Salah Nouaim
11380 US 401 N
Fuquay Varina, NC 27526
RE: Dabbing Chicken

A plan review was received by this office concerning the construction of the above referenced facility. The plans are not approved and the application is being returned at this time with the following comments:

Dabbling chicken
Floor plan

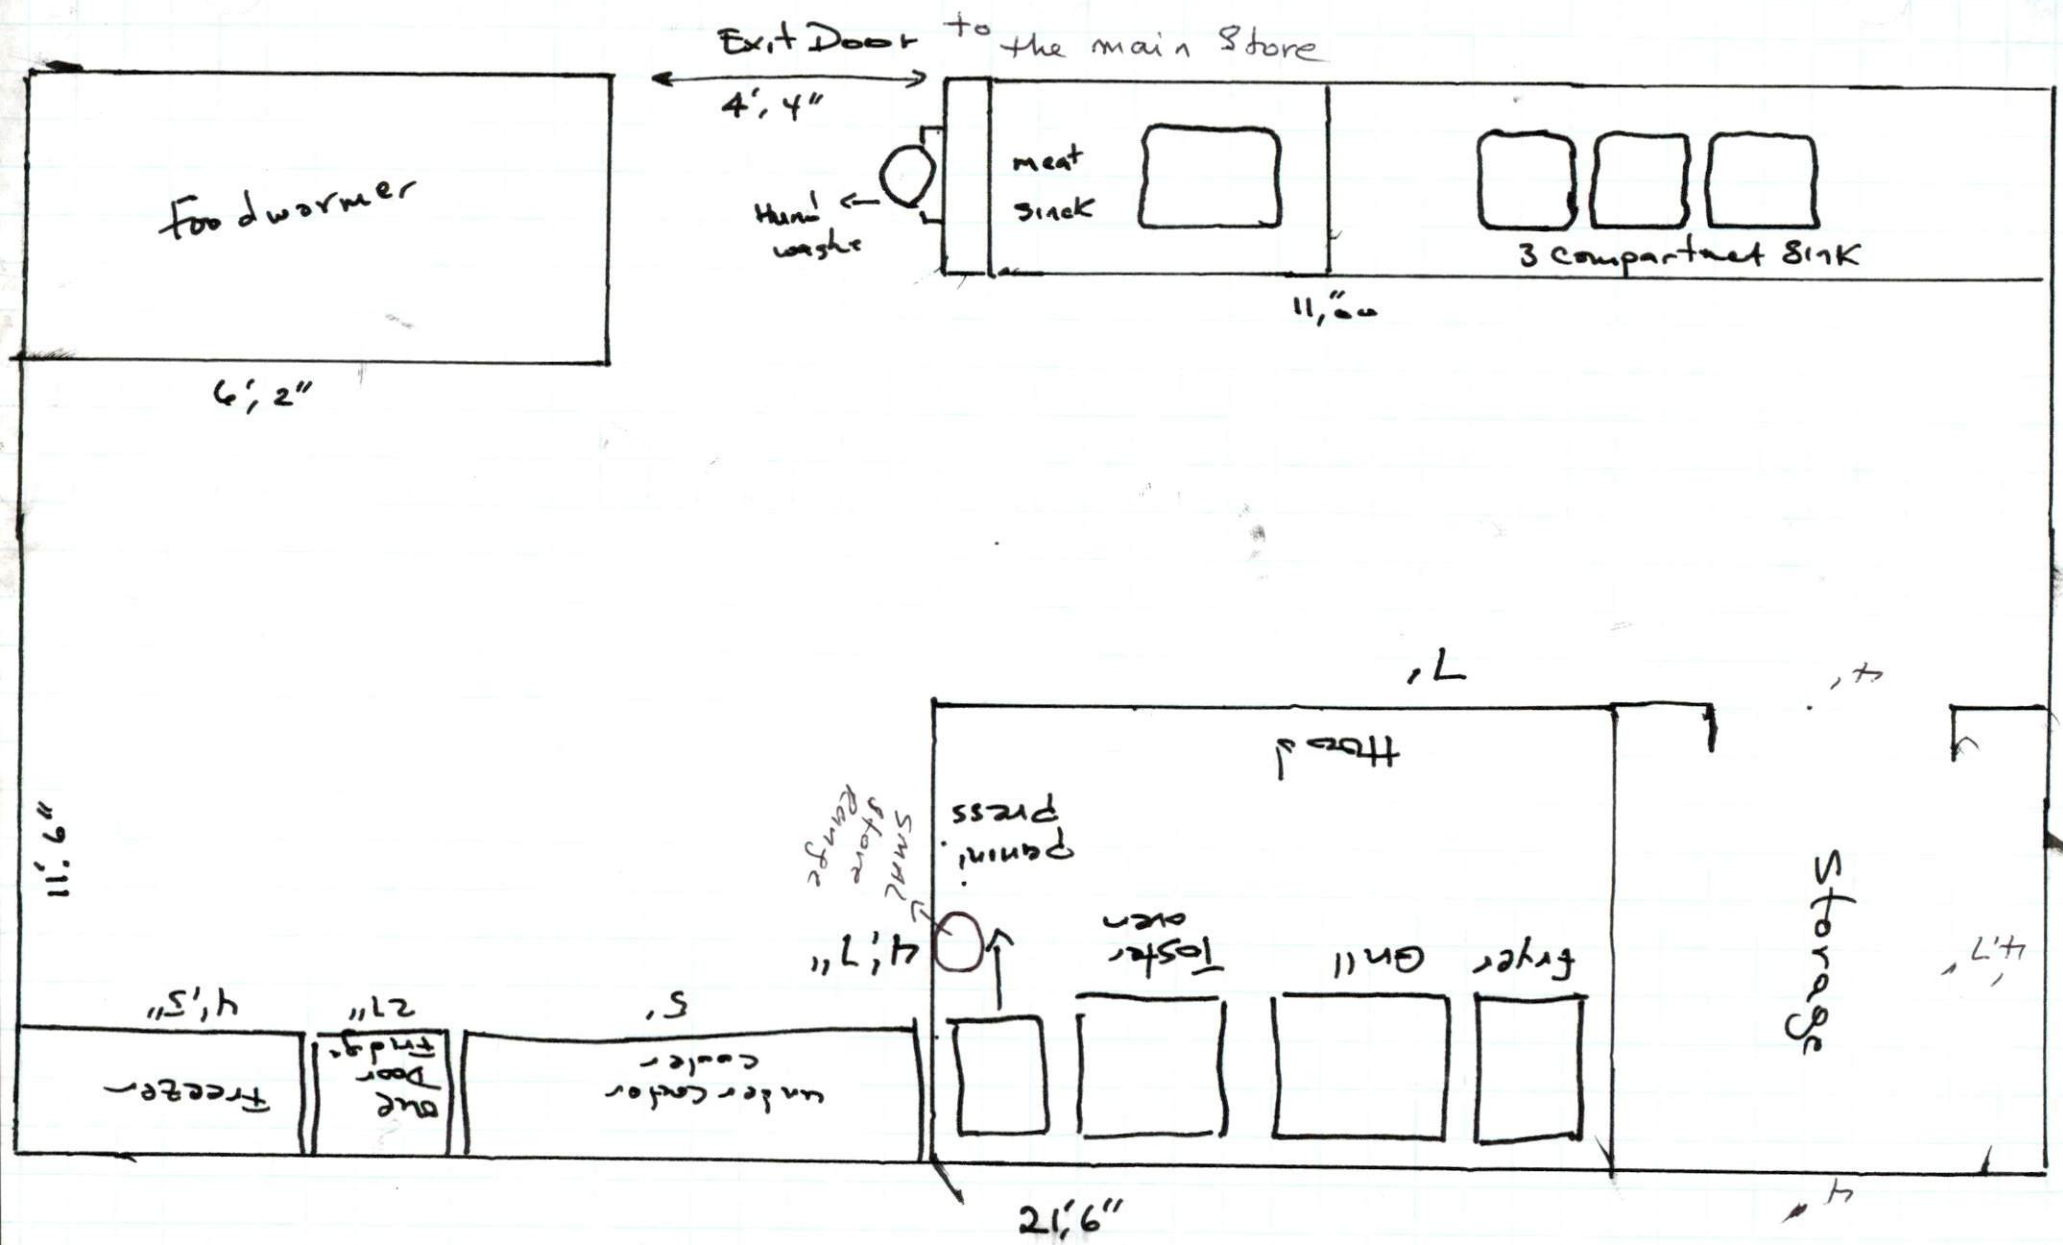
- Specification sheets are missing for small stove range, panini press, soup kettle, rice cooker and toaster oven.
- No location provided for rice and soup holding equipment.

- The application has zero marked for number of prep sinks however there is a prep sink on the layout. The size of drain board in inches on the application is 1.5. Please provide truthful information regarding the number and size of prep sinks.

- The application has 2 compartments indicated for manual ware washing. The layout indicates there is a three compartment sink. The length of drain boards in inches as indicated on the application is 1.5. Please provide truthful information regarding the ware washing sink. The layout must match the application with respect to equipment provided.

- No location or size of can wash facility was provided.
